From: Ian Hayward [REDACTED]
Sent: 14 March 2018 11:14
To: Simon Davis
Subject: RE: LAND AT FONTWELL AVE CHICHSTER PLANNING AL/136/17/PL

A revised plan CHI/17089/P has been provided.

PROPOSED SITE PLAN 1:200

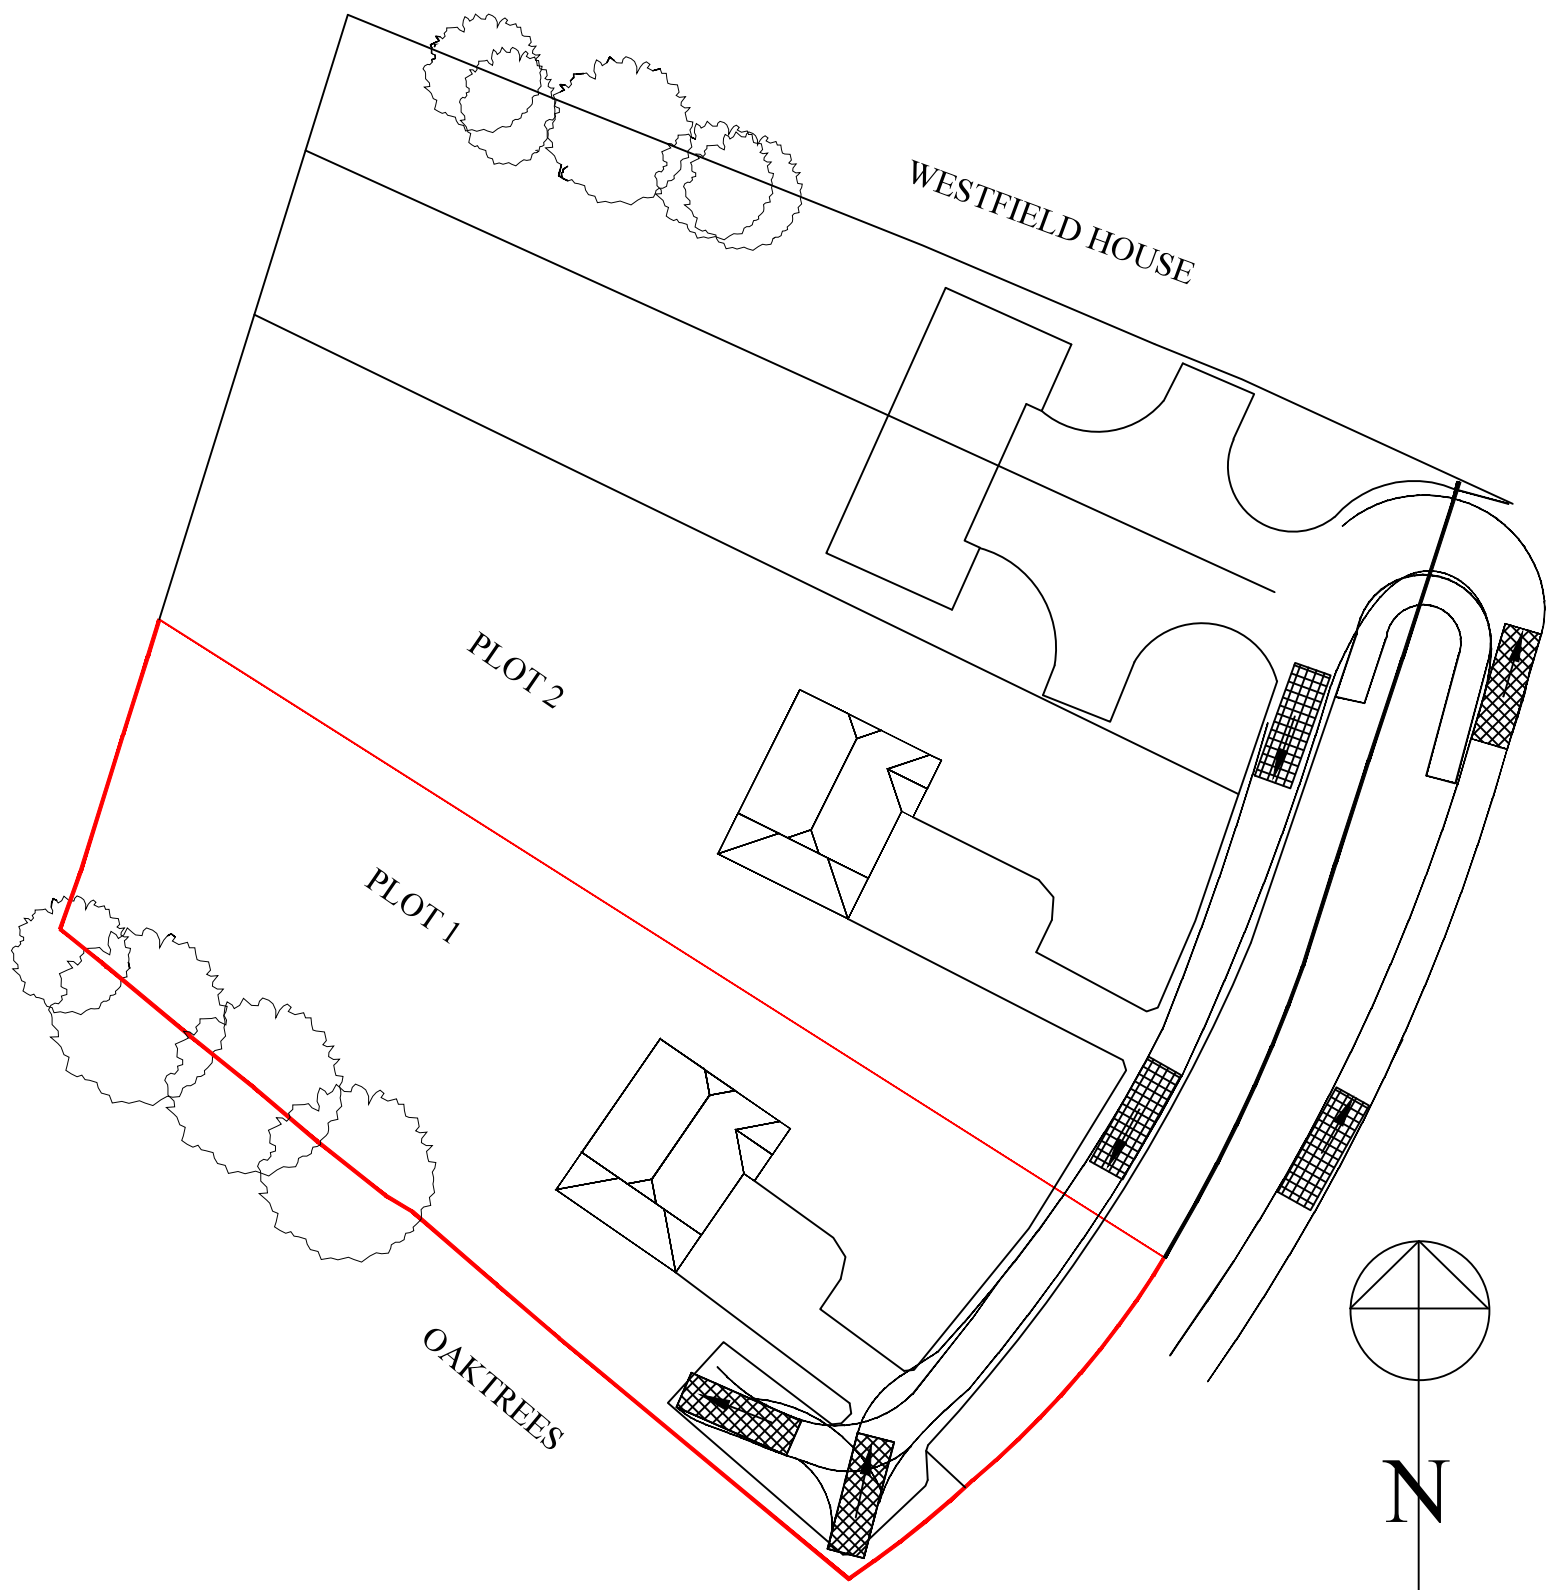
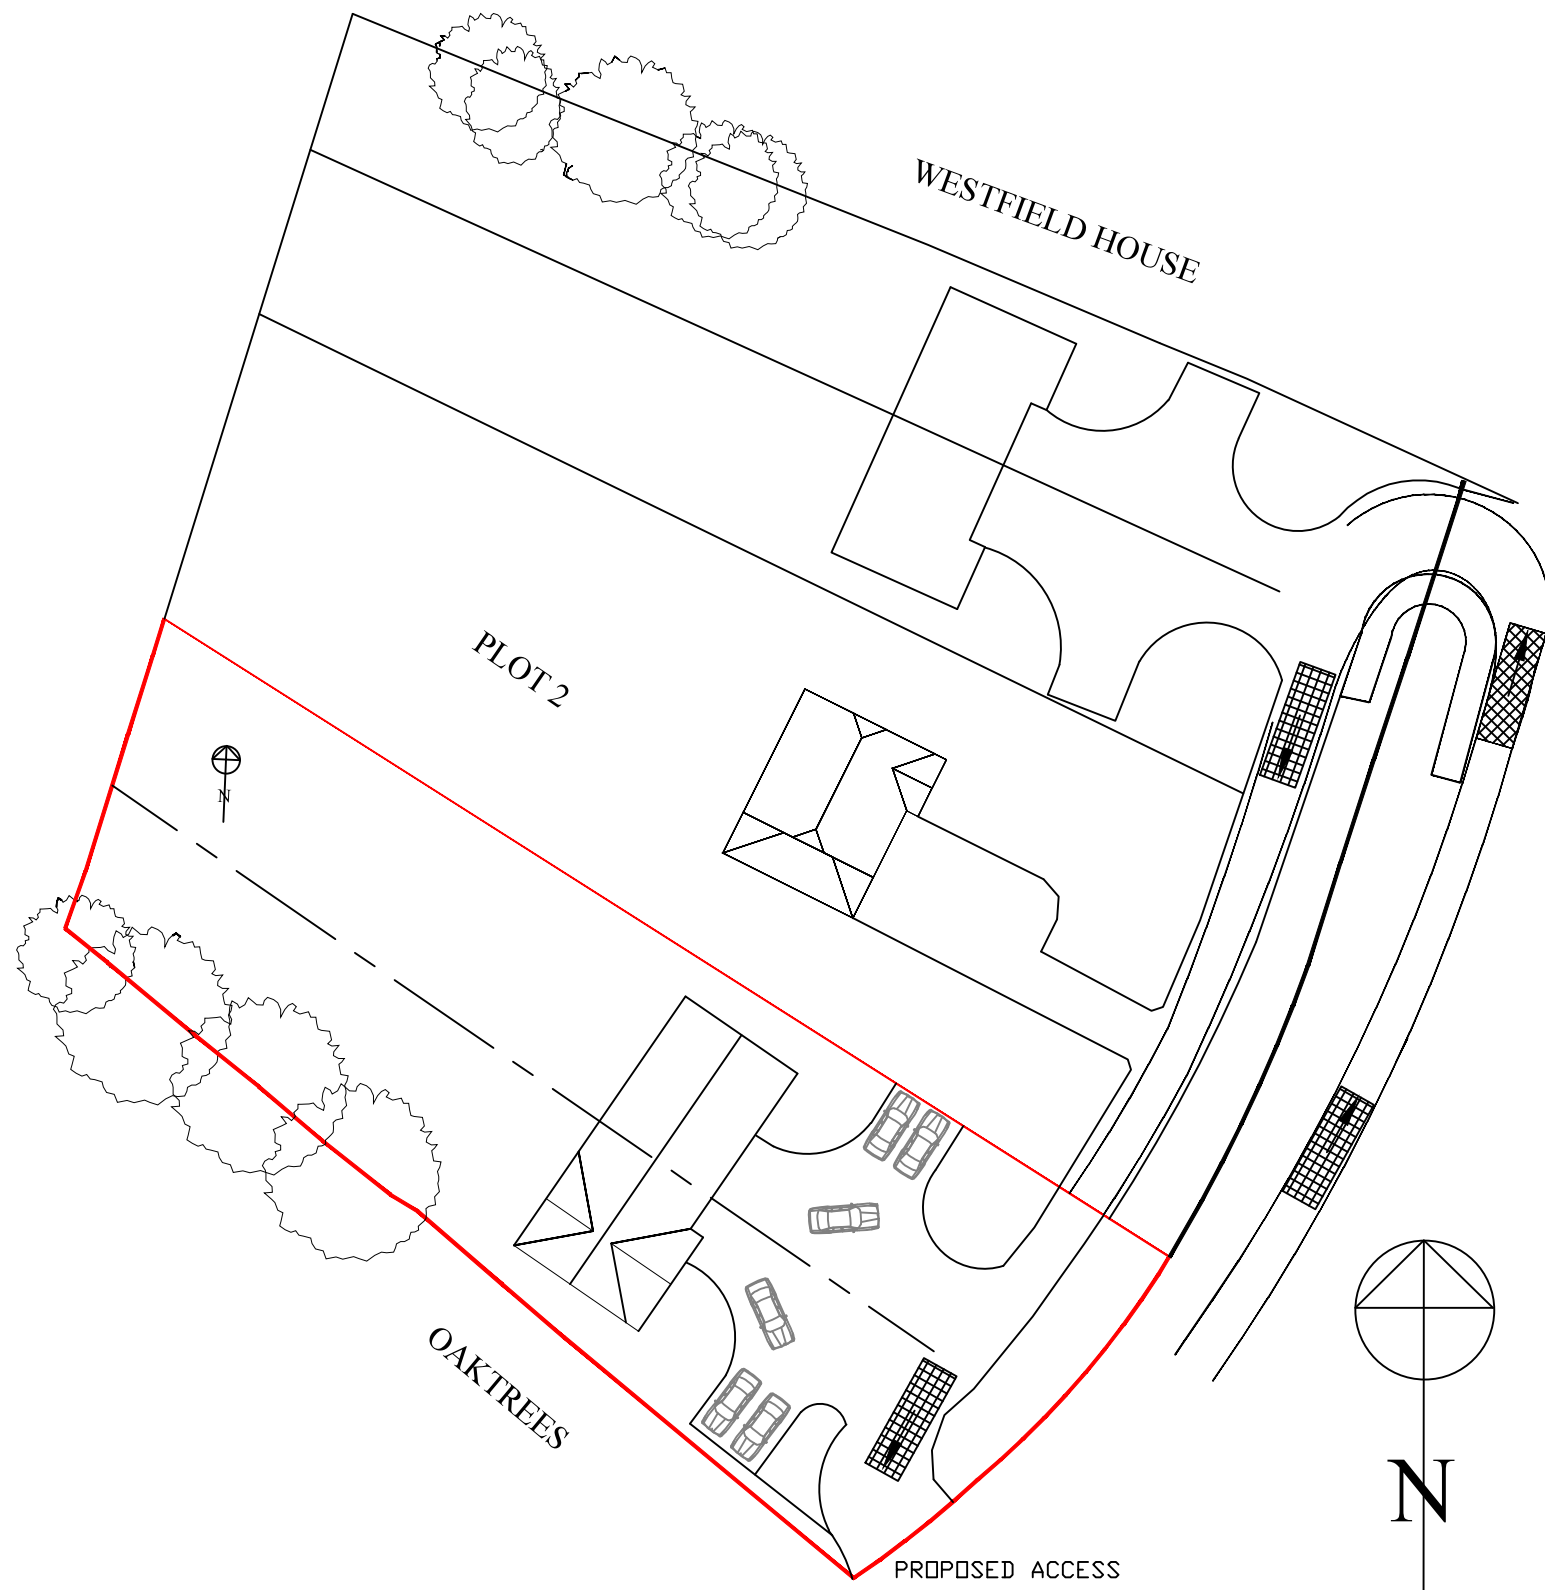
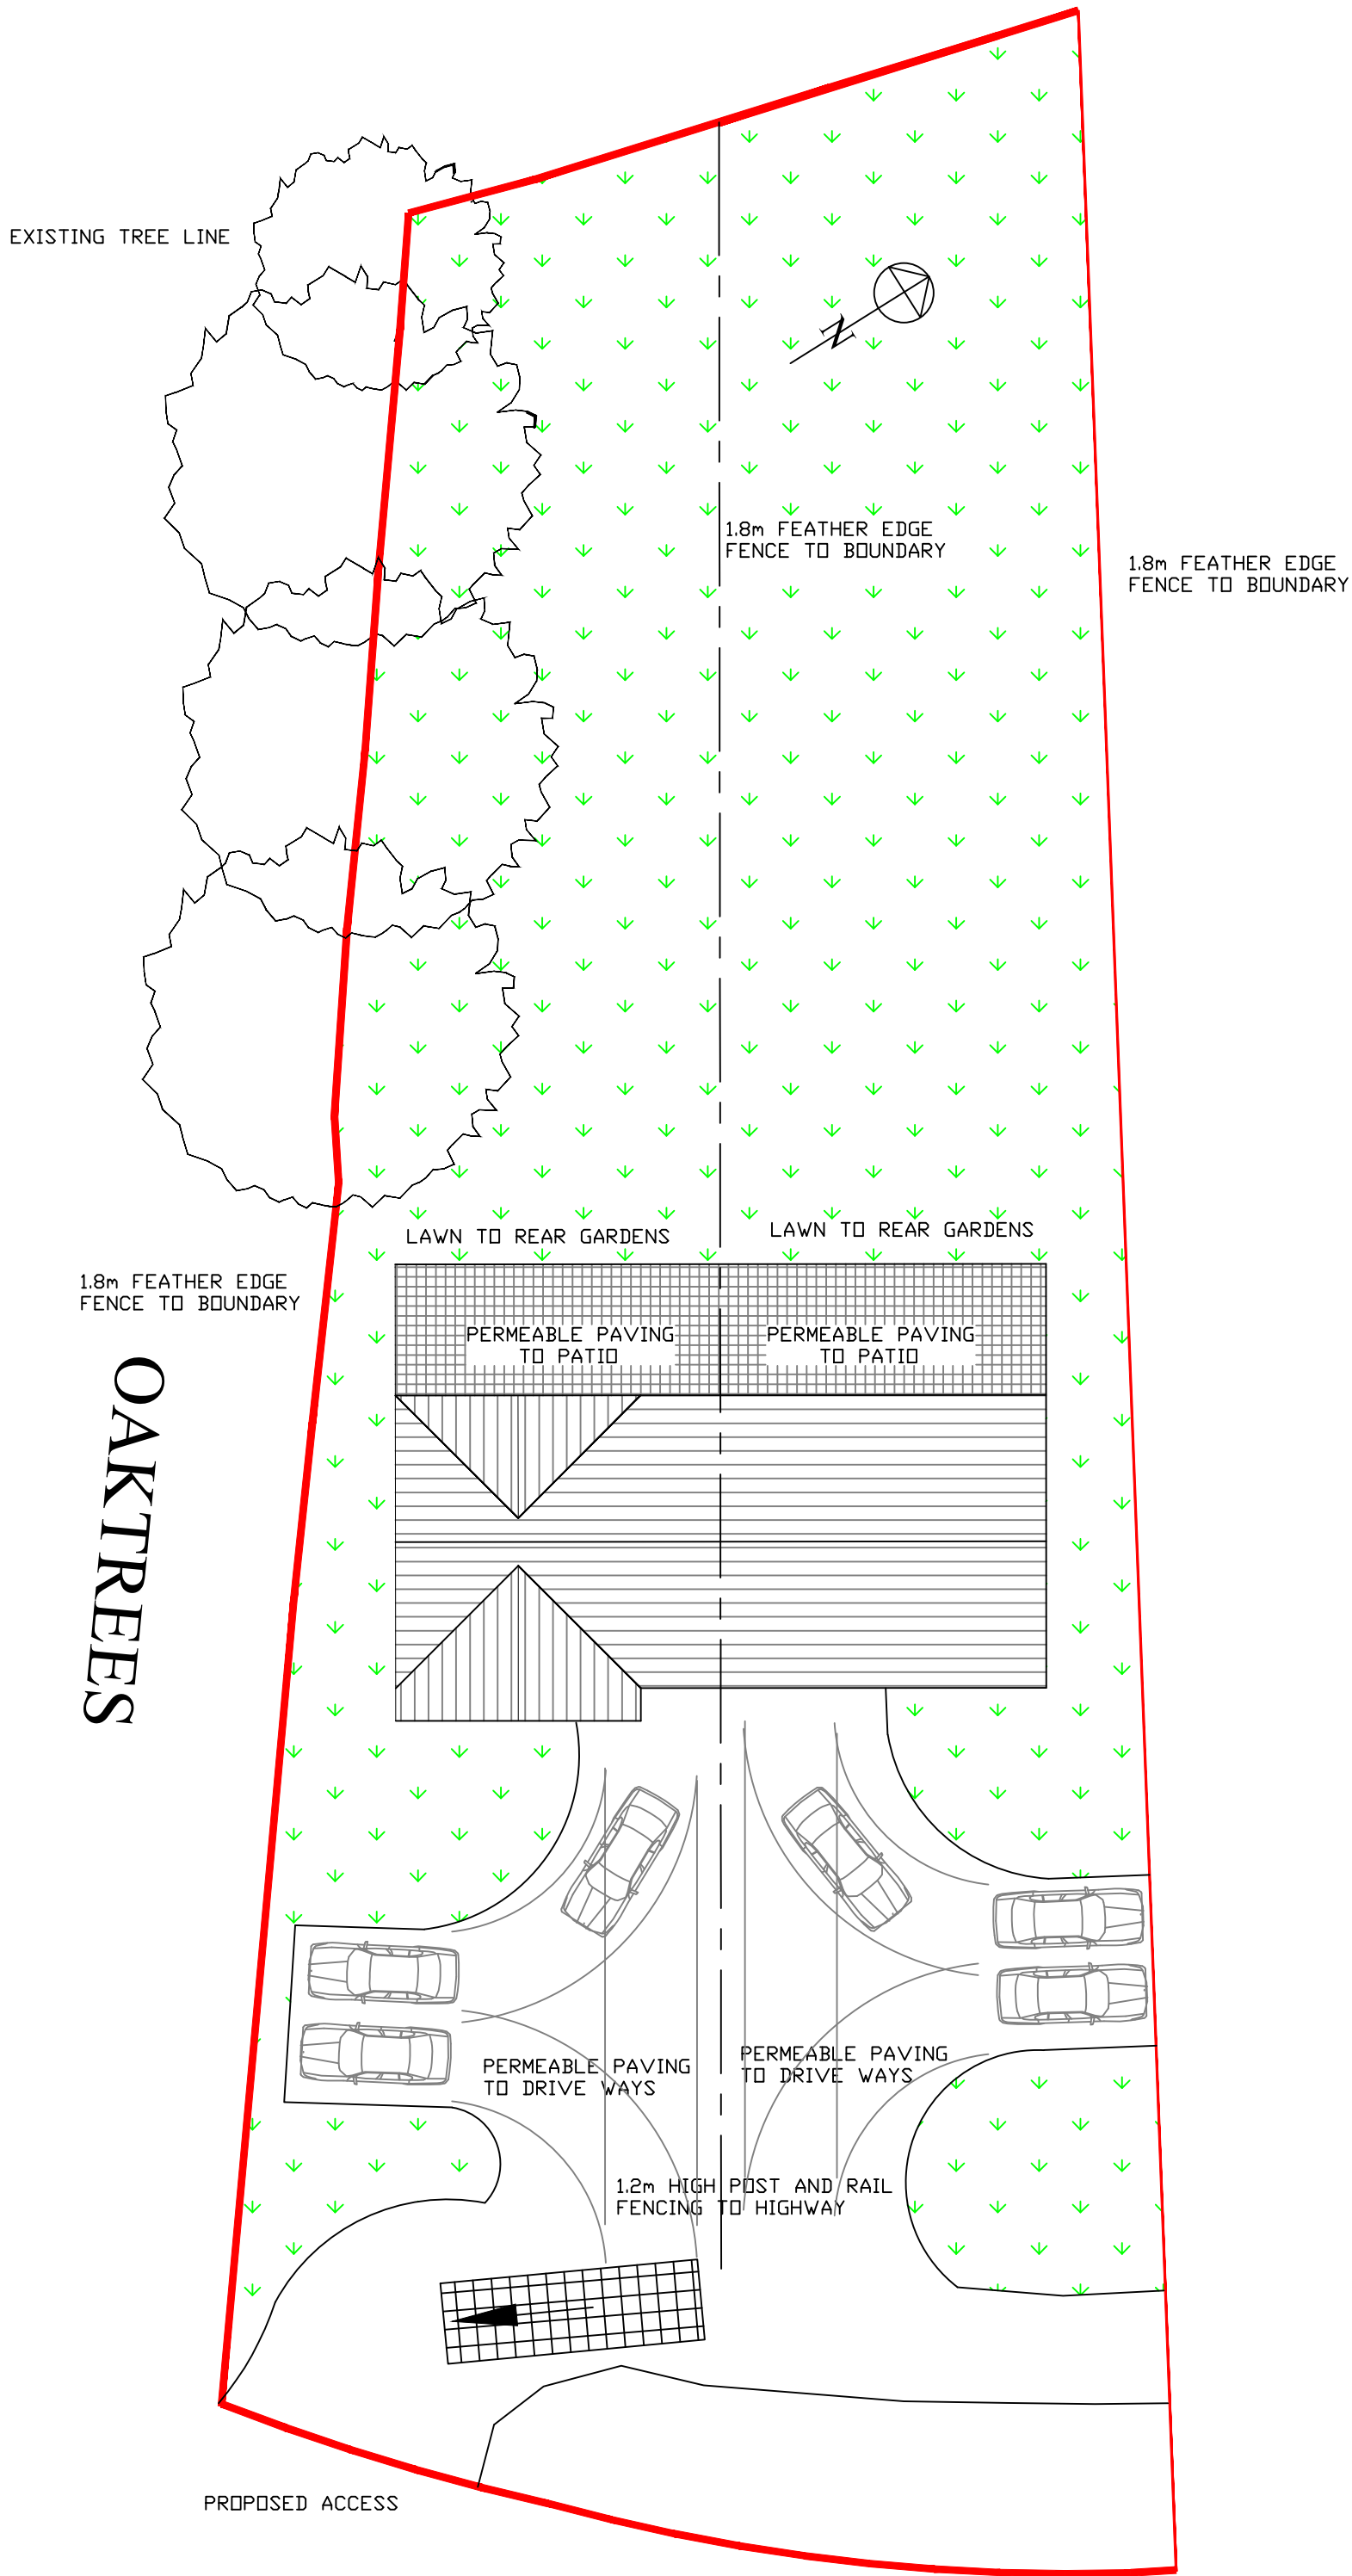
I note a 2.4 x 54 metre visibility splay has been annotated on the proposed site plan. This is below the minimum 59 metres splay as calculated using Manual for Streets Stopping Sight Distance calculation coefficients based upon the historic speed survey data of (37.1 mph 85th percentile approach speed).

In addition this splay has been drawn to the opposing side of Fontwell Avenue, the splay should be drawn to the nearside carriageway edge, or with an offset of 1.0 metres, in line with current guidance and standards within Manual for Streets.

While vehicle tracking has been provided at the proposed southern access point it does not show how the vehicle large emergency / service vehicles will then access the internal access arrangements.

I would not be minded to accept that this latest information demonstrates that safe and suitable access can be achieved at the southern extent of the site. The conclusions of my response dated 07/02/2018 would still be considered relevant. Please can you re-raise with the applicant?
